May 26th, 2025

Re: SSD-78996460.- 16-24 Lord St & 21-27 Roseville Ave, Roseville

DRAWING NO.
SSDA-251

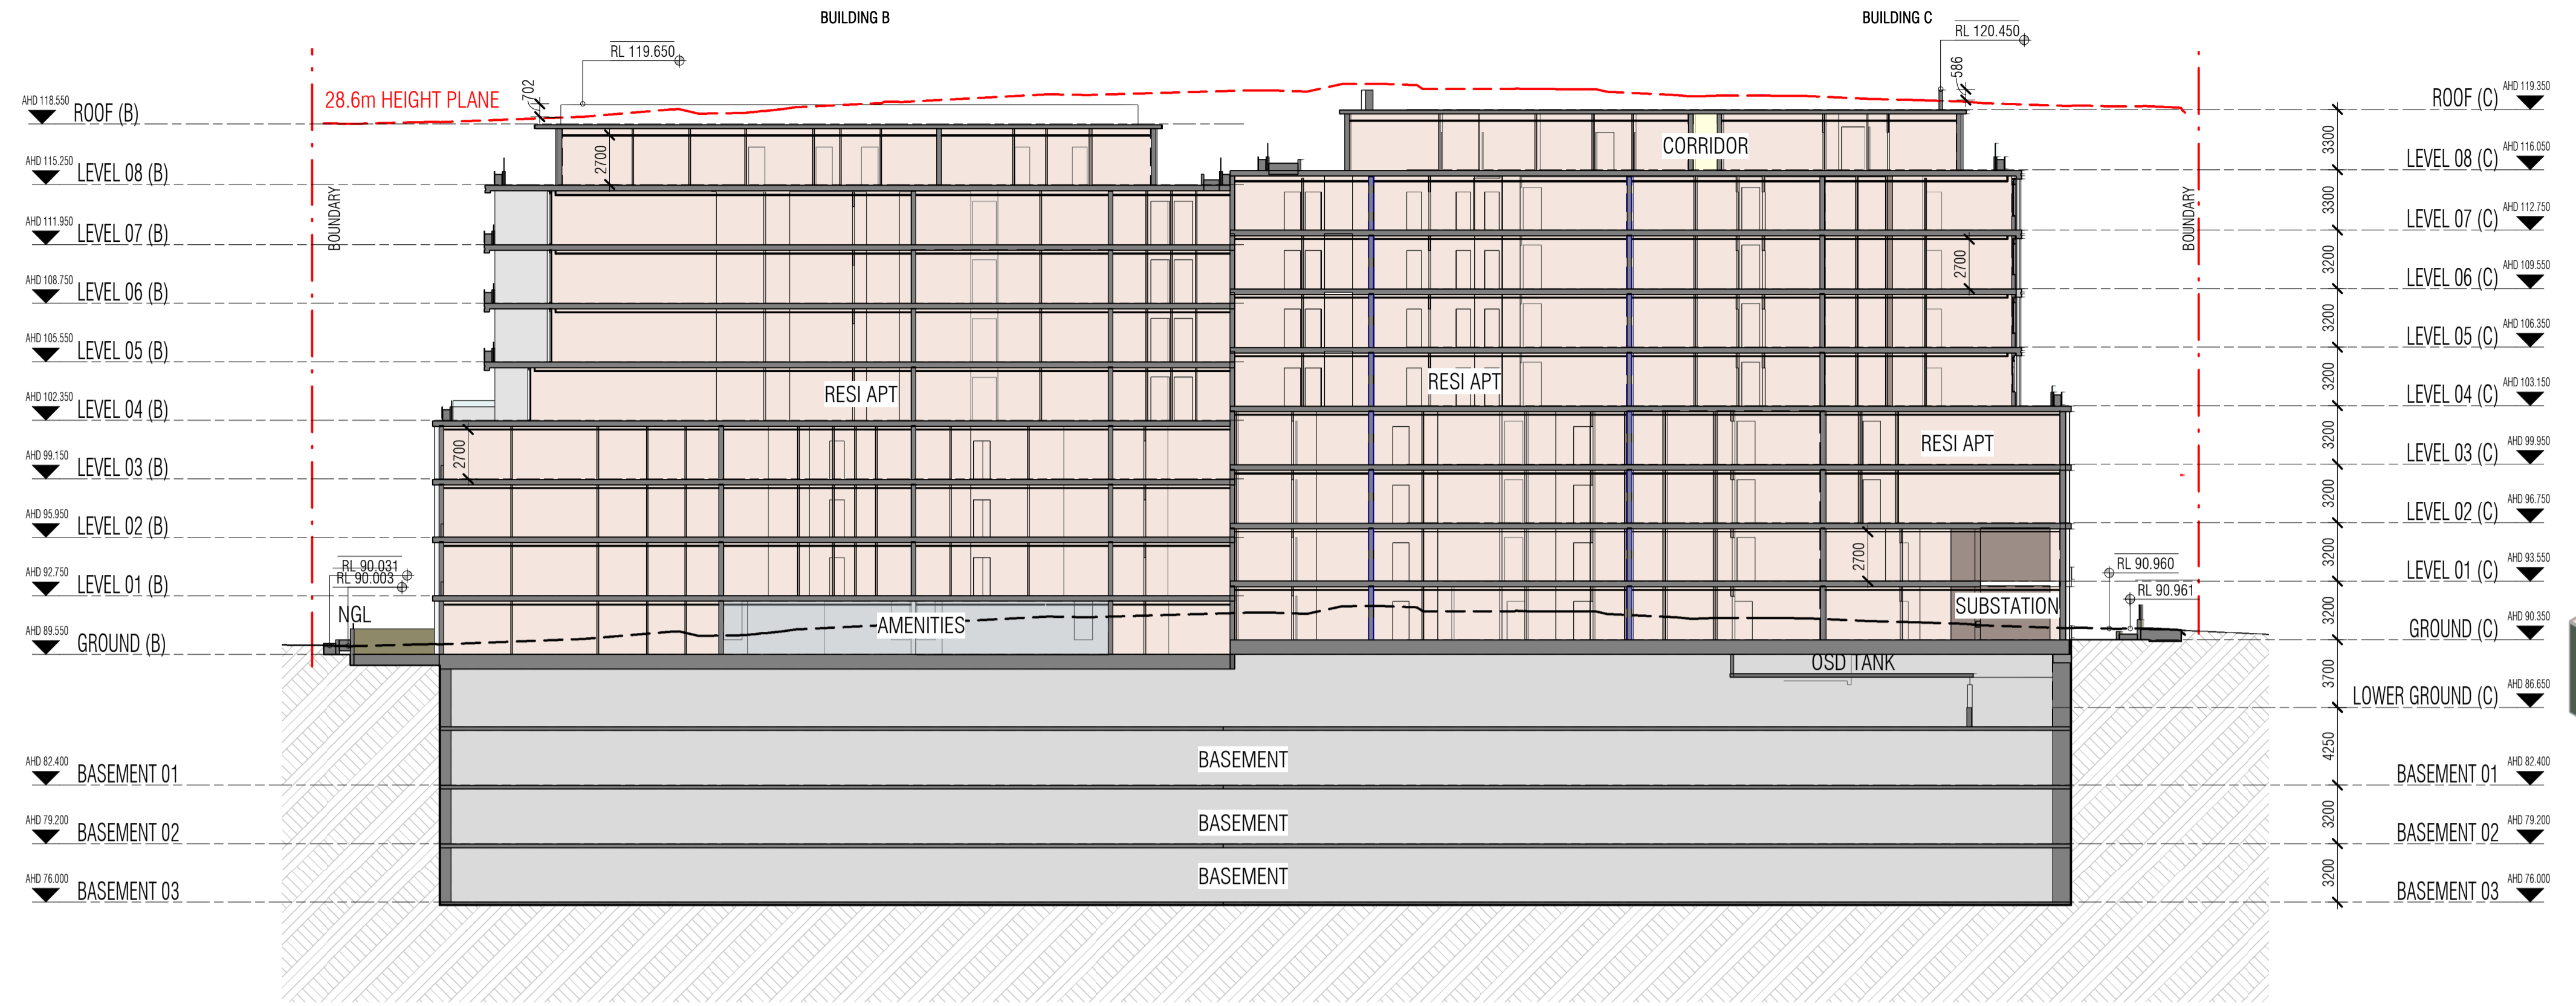
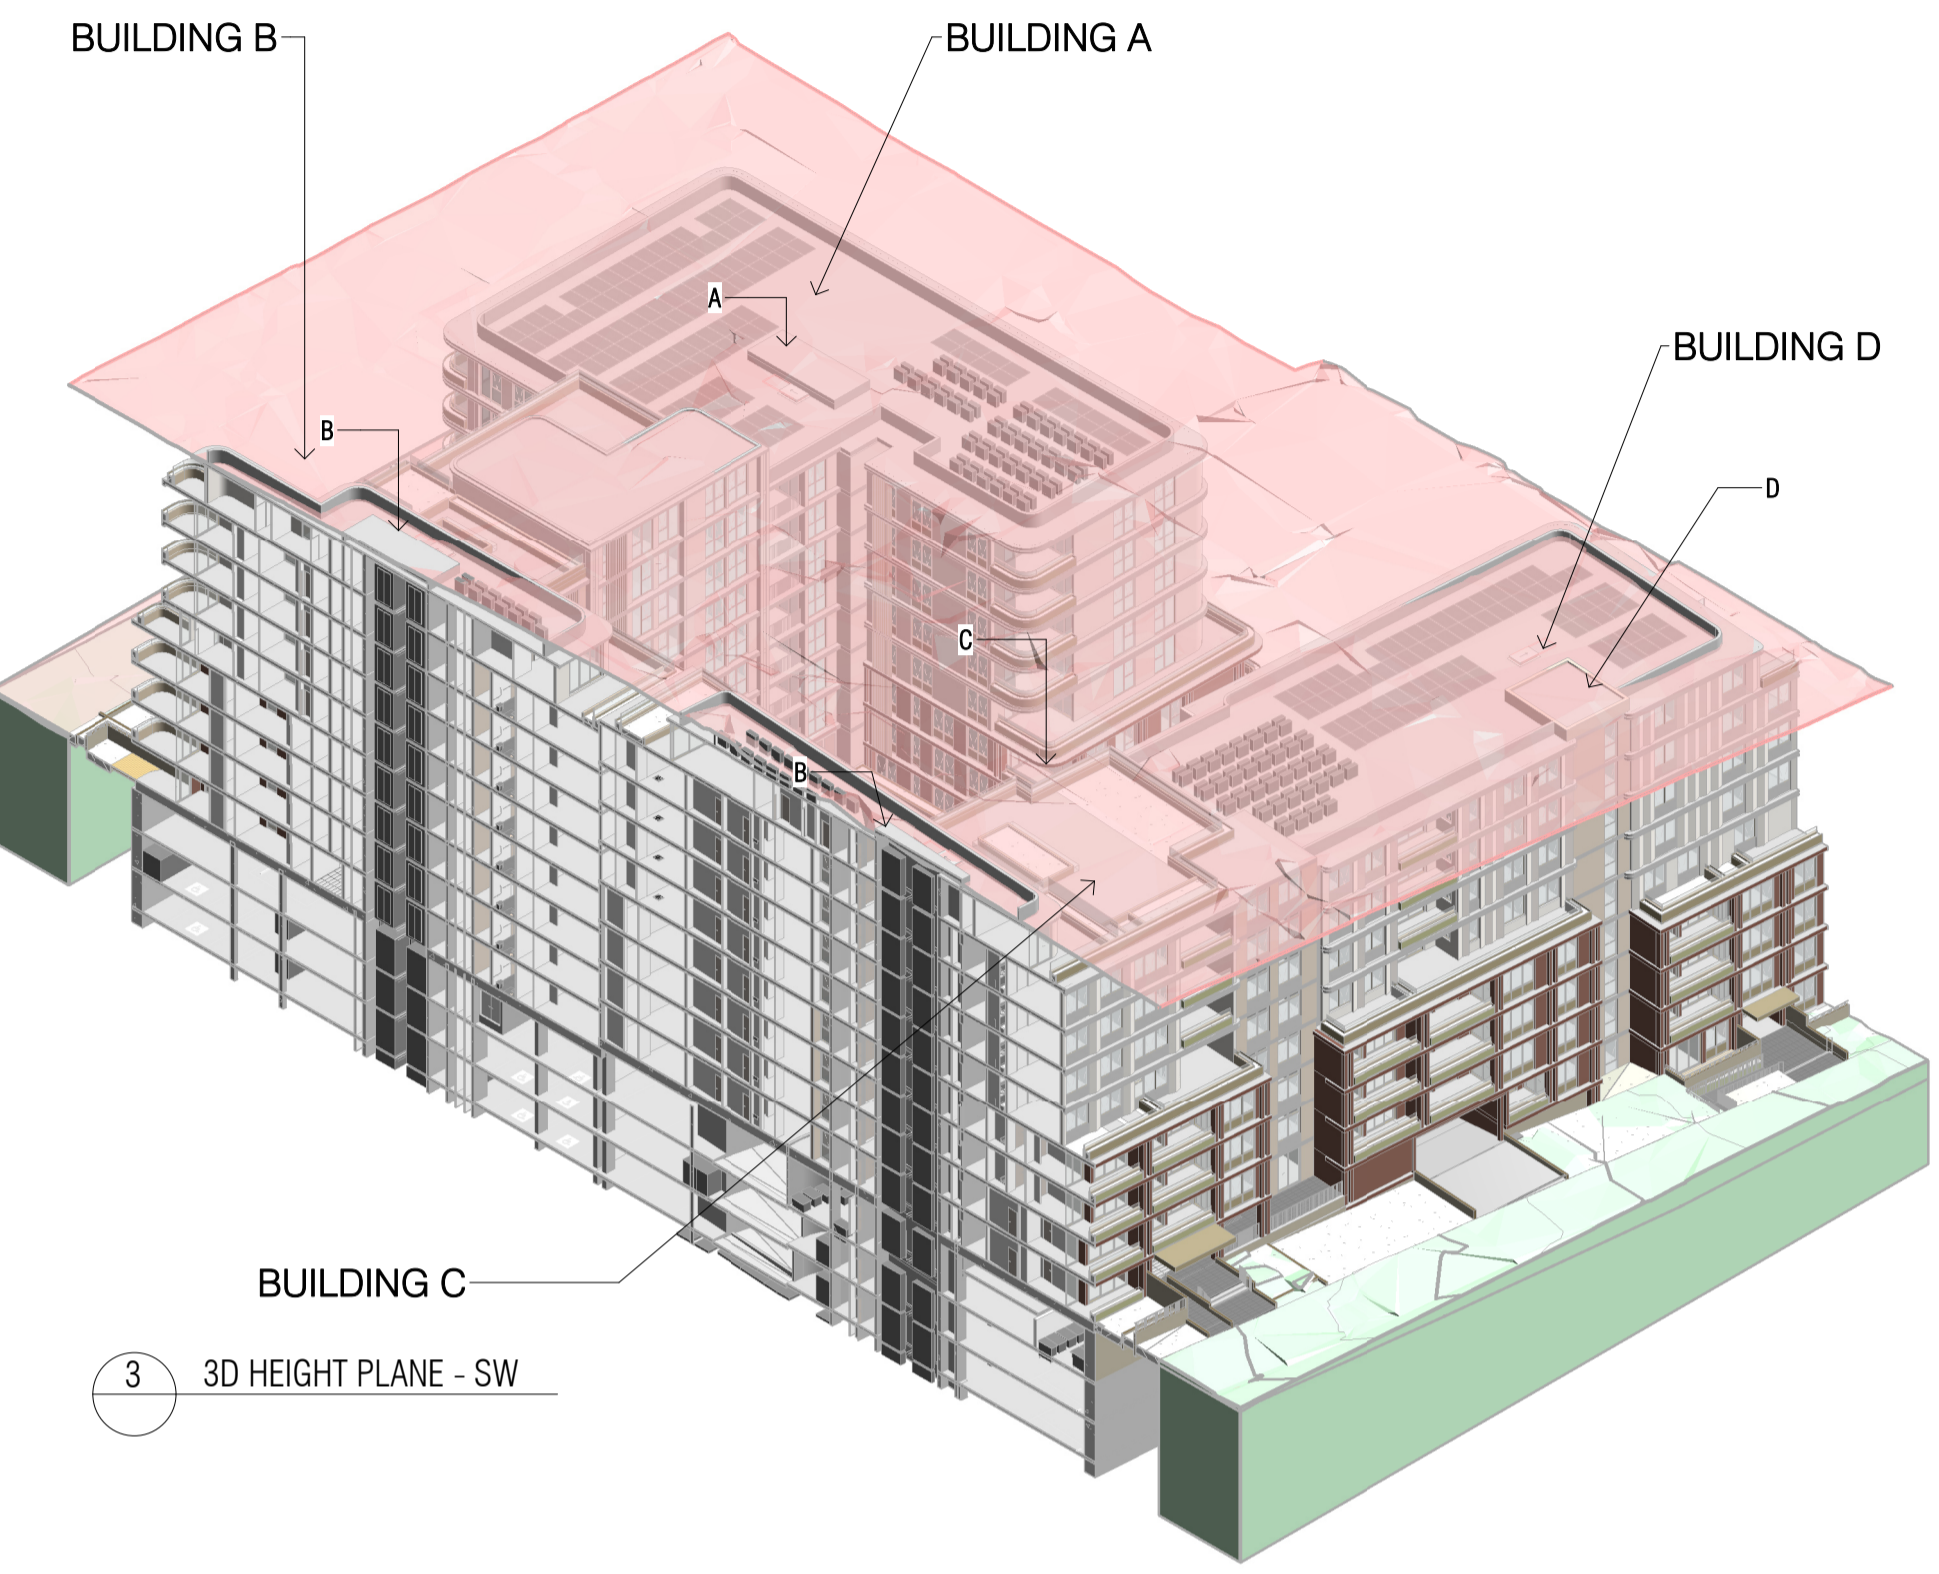
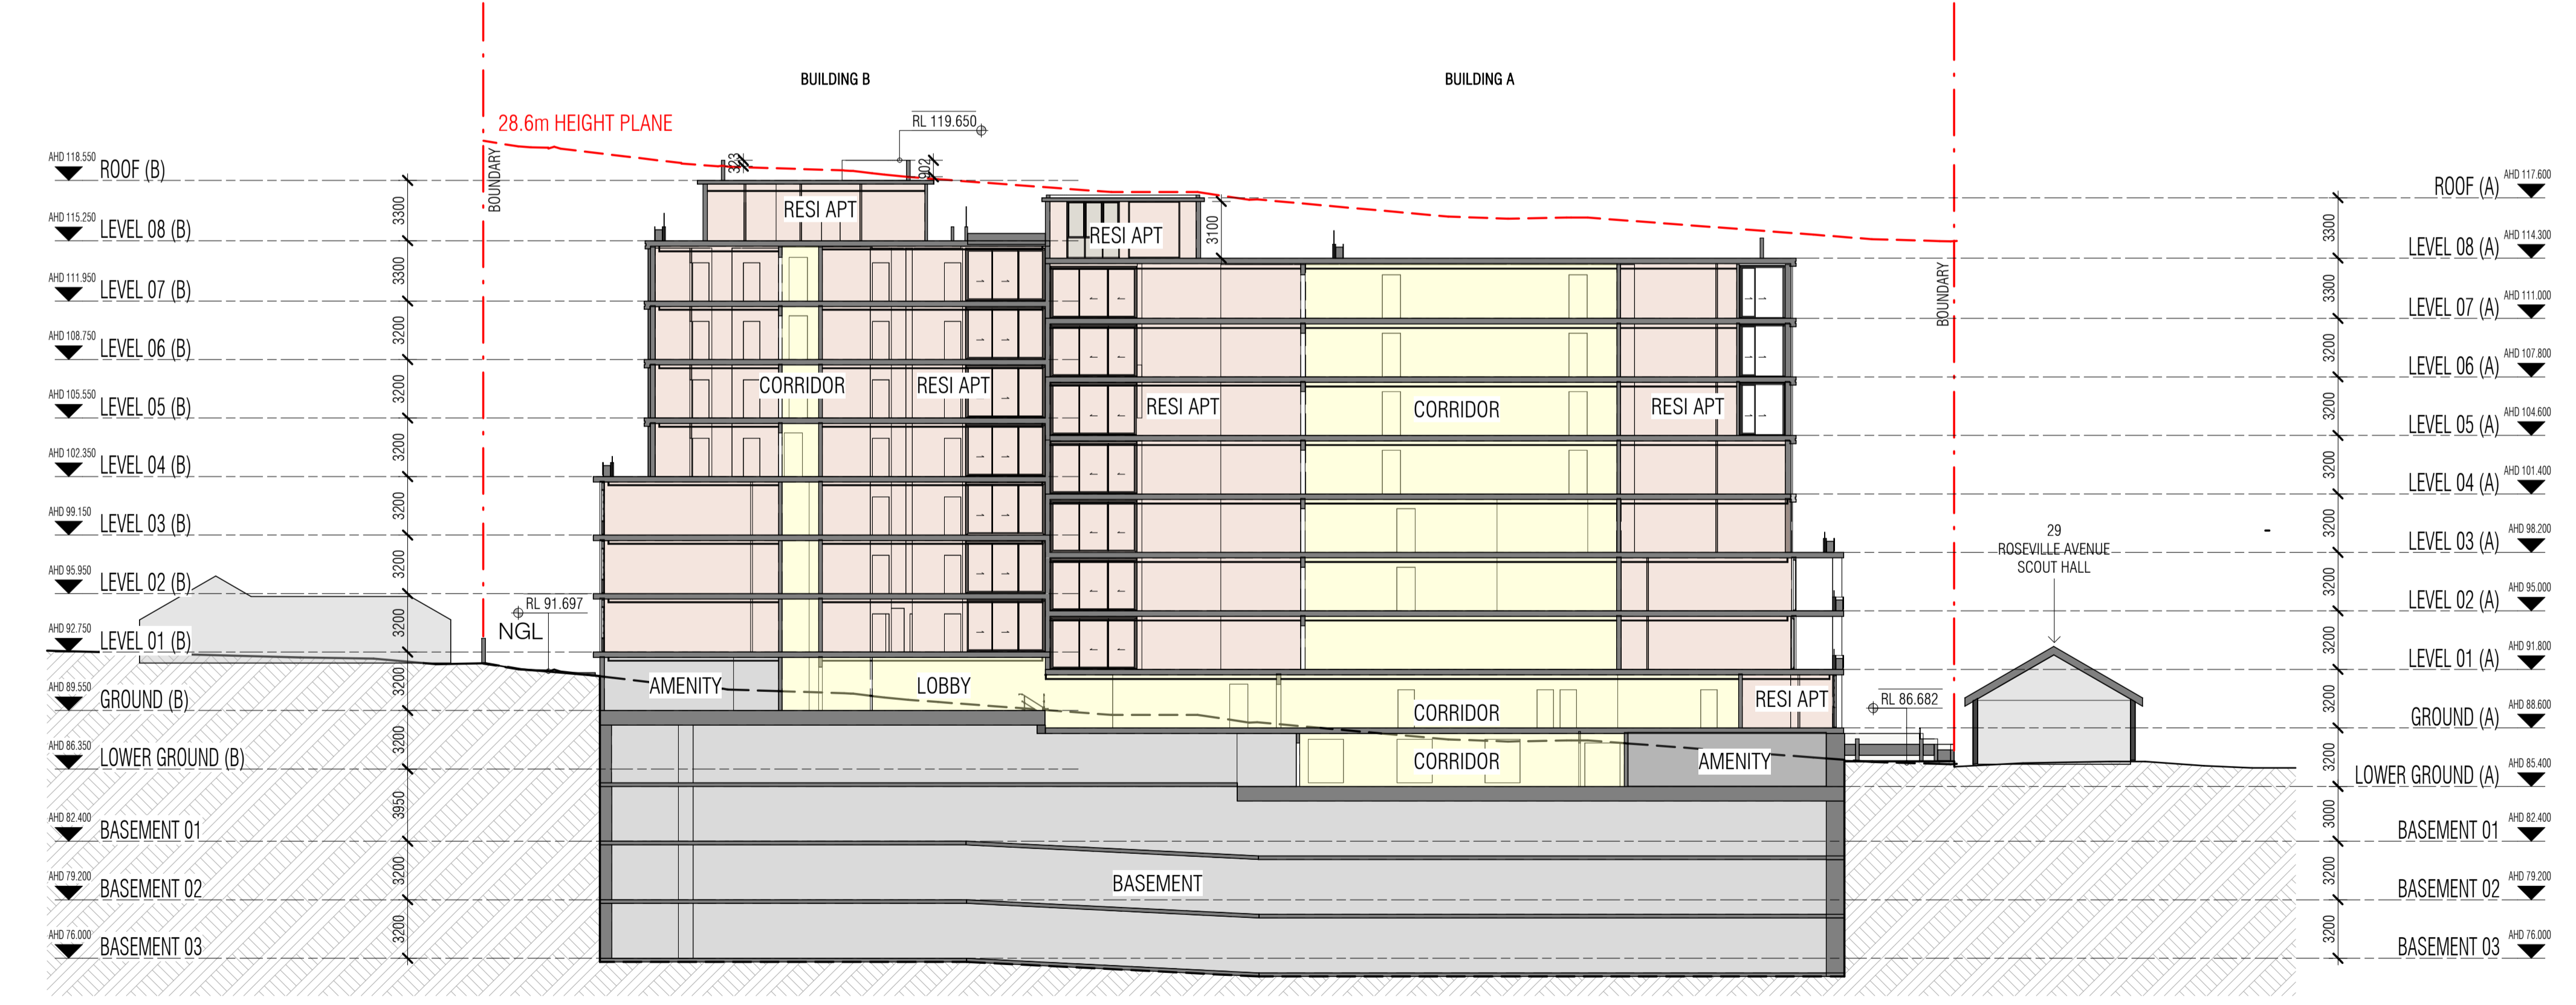
By the inclusion of affordable housing, the proposal takes advantage of a 30% increase in allowable height. But even with this generous allowance the developer (Appendix H Variation Request) seeks a further increase of between 2.3m – 1.6m over various parts of the building. The proposal acknowledges this non-compliance in Appendix B.

This combination of excessive height and inadequate setbacks will result in a visually dominant building that detracts from the character of the streetscape and amenity of neighbouring properties including the Roseville Presbyterian Church at 28 Lord St.
